Preliminary Report on Metrolink Route and its Potential Effect on AerCap House

Waterman Moylan Consulting Engineers Limited

Client Name: Hines
Document Reference: 22-117r.101
Project Number: 22-117

Drawing Title  
**Figure 14.2 Groundborne Noise from Tunnel Boring Machine**  
Sheet 1 of 7

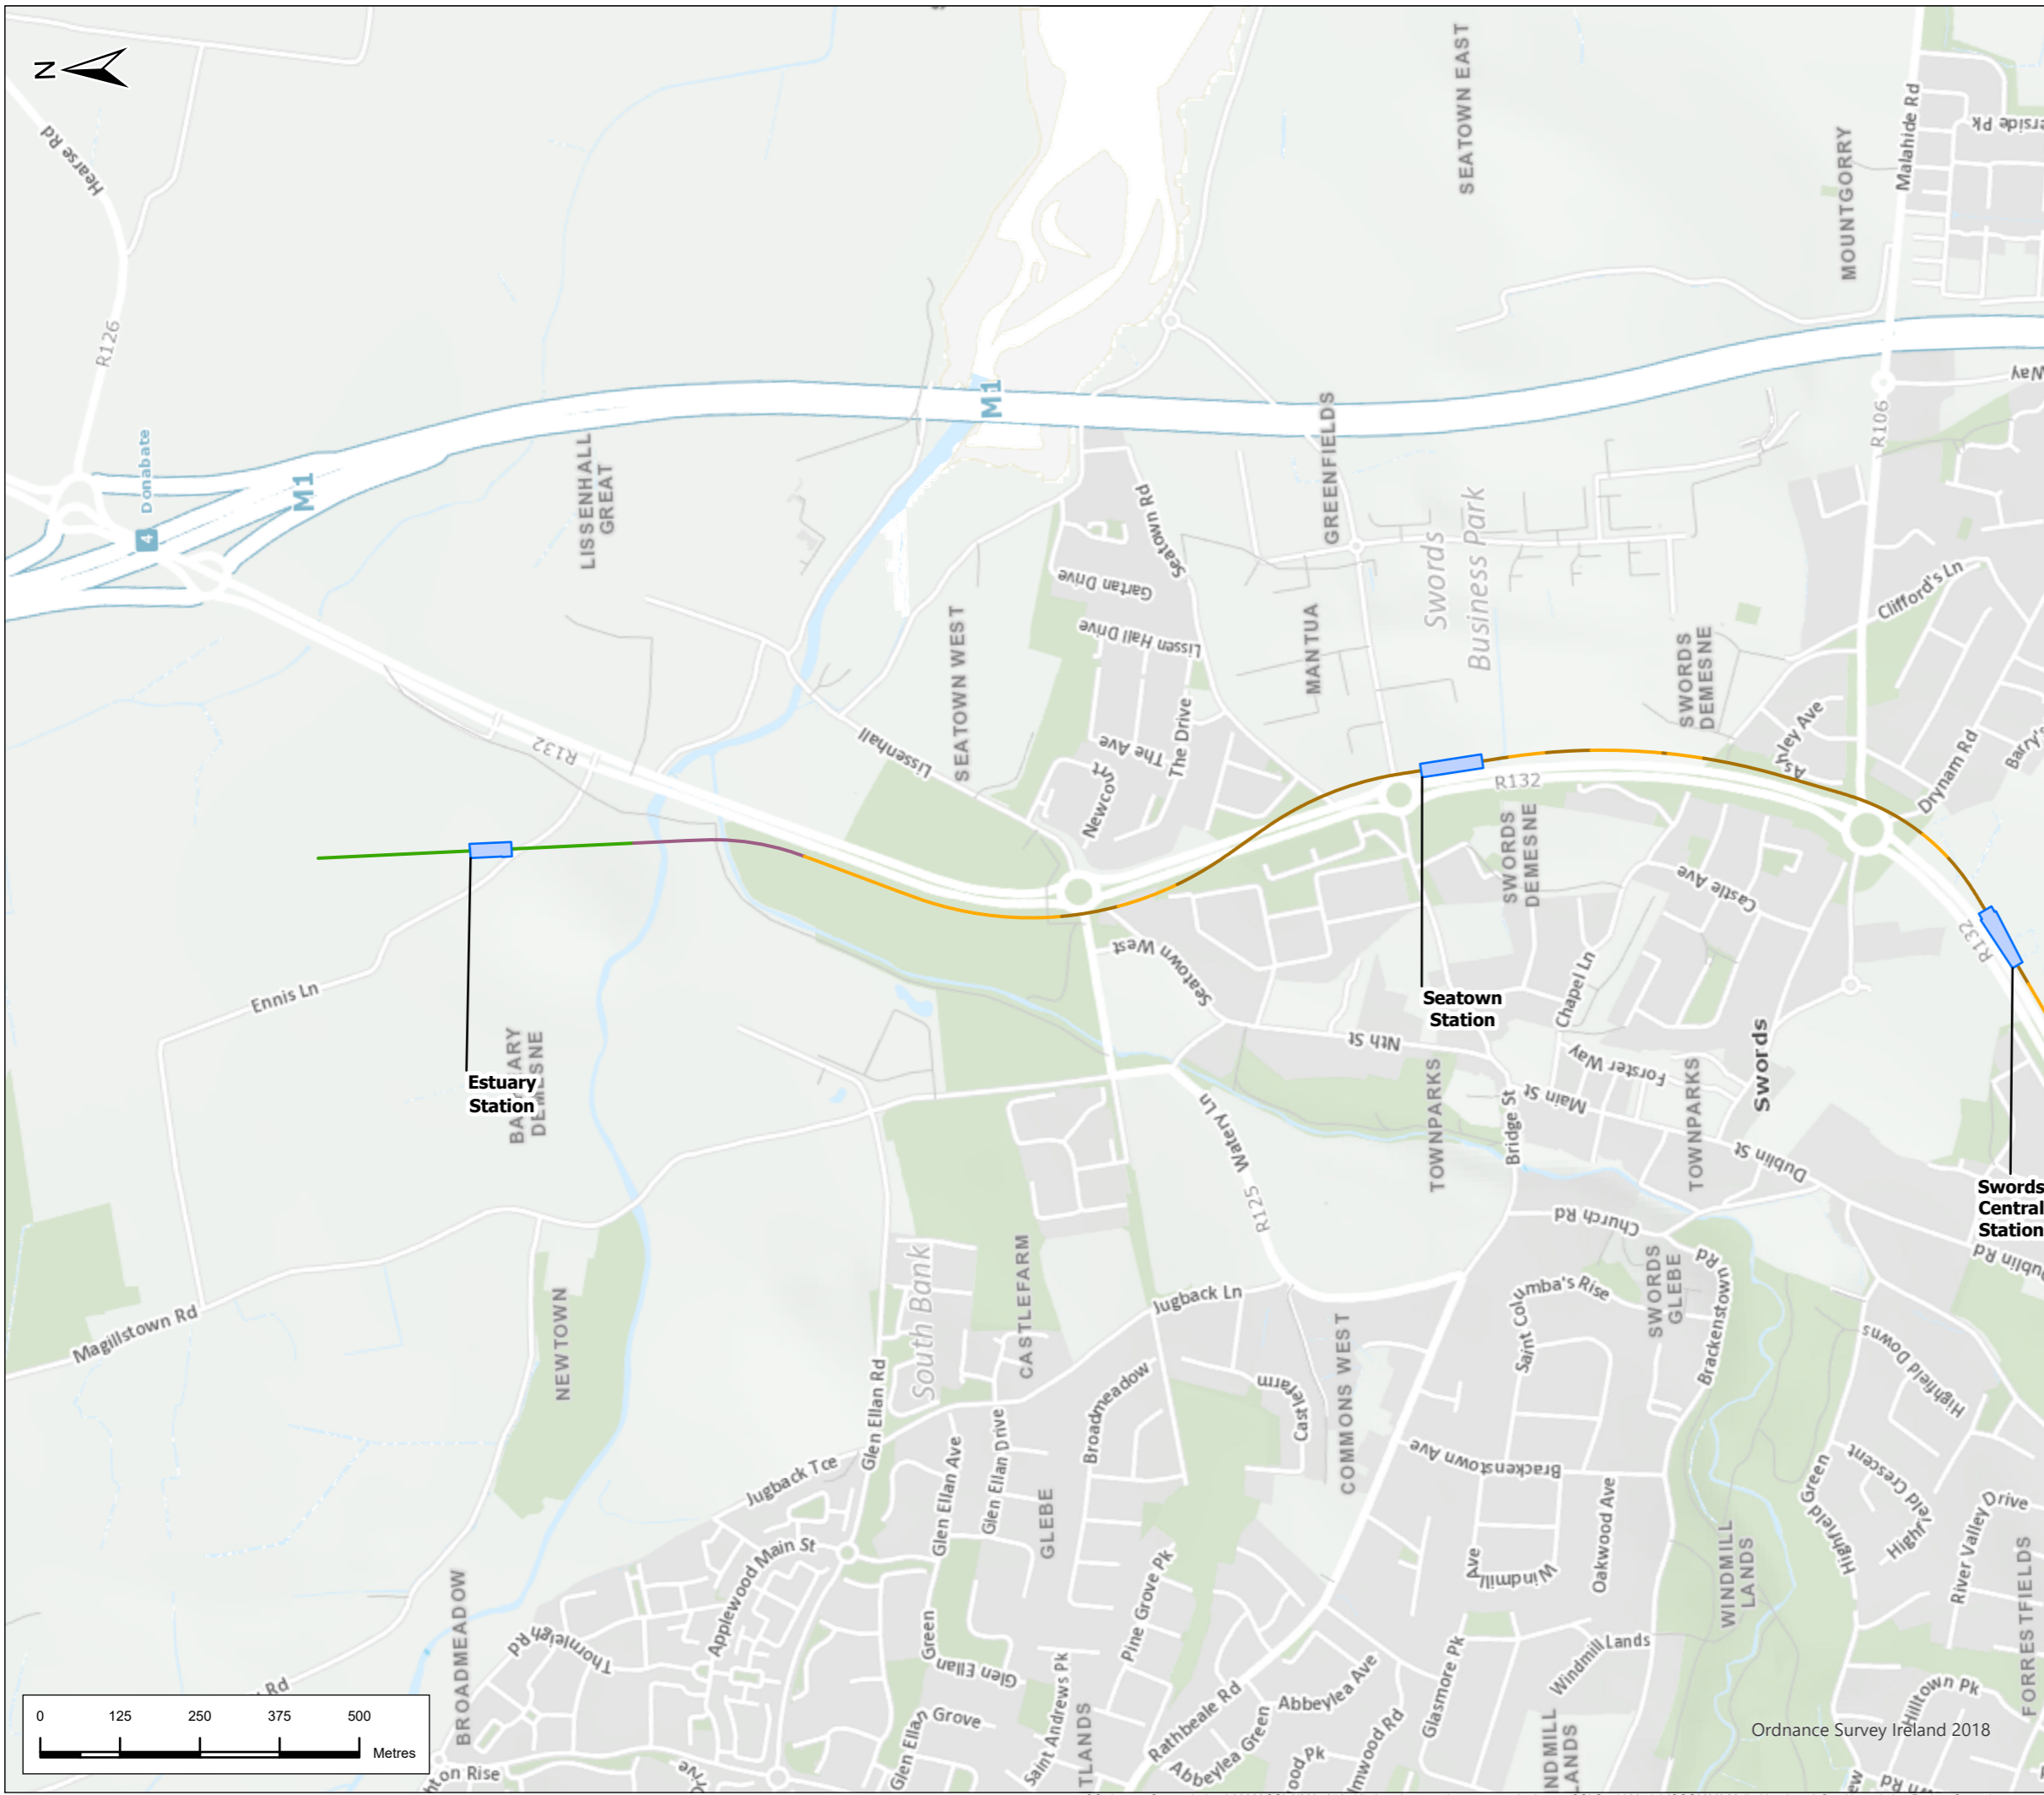
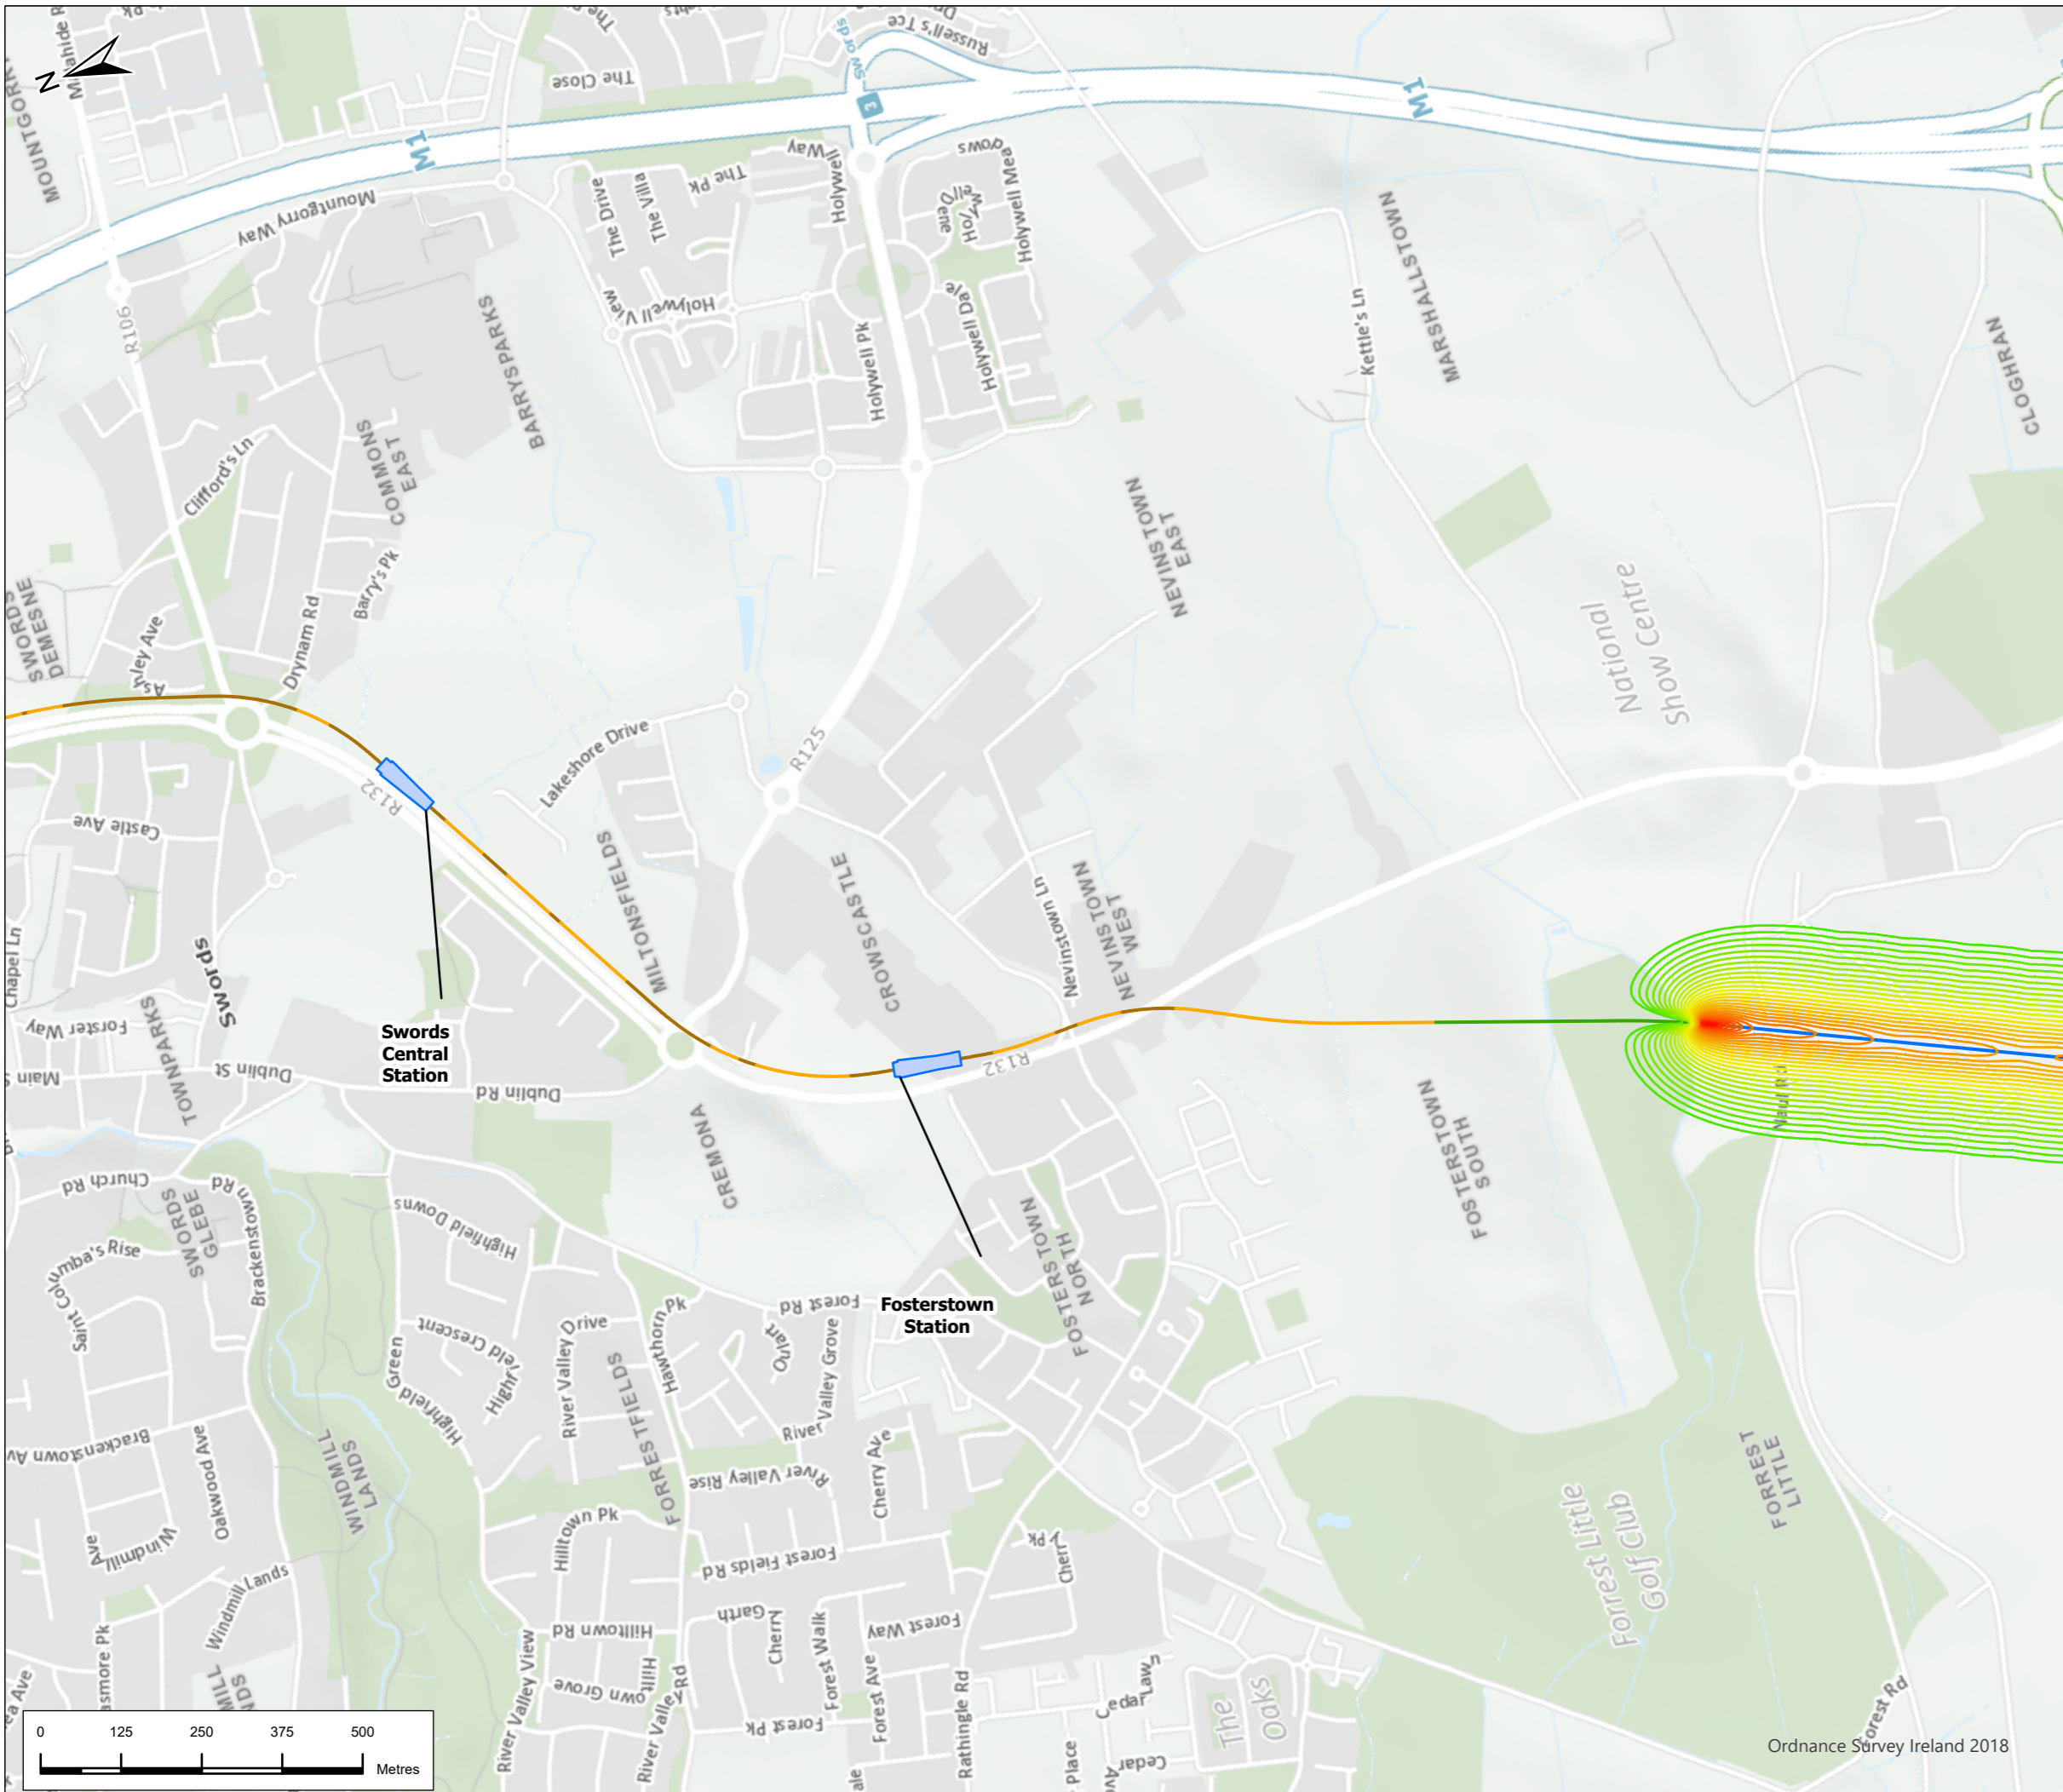
Observation (Waterman Moylan) 2: The construction information provided by MetroLink has been reviewed. We refer to the following points: a) Metrolink has assessed the "Groundborne Noise from Tunnel Boring Machine" and presents its findings on drawing no. ML1-JAI-EIAROUT-XX-DR-Y-14009 (a copy is attached to this submission). This drawing indicates MetroLink will generate an additional 50db directly under the location of our Client's building which is unacceptable.

Waterman Moylan Response 2: The response suggests that we need to accept the nuisance caused by the proposed works, and there is nothing that TII are willing to undertake to prevent this nuisance.

TII Response 2: *"Appendix 14.5 Groundborne Noise and Vibration Blasting Modelling Results presents predicted groundborne noise and vibration levels during the construction and operation phase of the project. The prediction of groundborne noise during TBM passage for the AerCap House (65 St. Stephen's Green) is 49 dB LASmax, which is above the 45 dB LASmax threshold, resulting a significant impact on the buildings operation for the limited duration of TBM passage. Unfortunately, there are no effective methods available to reduce groundborne noise or vibration from TBMs at source, but noting that the duration of this impact will be in the order of up to two weeks as the TBM passes. It is important to note that the noise level as the TBM passes will be noticeable and perhaps disturbing for some, but will not cause any damage to the property. TII will liaise with Hines Real Estate Ireland Limited to ensure the timing of these impacts are known. The principal mitigation measures aimed at minimising impacts are as follows:*

- *Advance public consultation and stakeholder engagement can greatly reduce the significance of groundborne noise effects, as building occupants would be prepared for the passage of the TBM and resultant elevated noise and vibration levels.*

- *TII will accept and consider applications for additional measures on a case-by case basis, in accordance with its Noise and Vibration Mitigation Policy (see EIAR Appendix A14.6, Airborne Noise & Groundborne Noise Mitigation Policy)."*
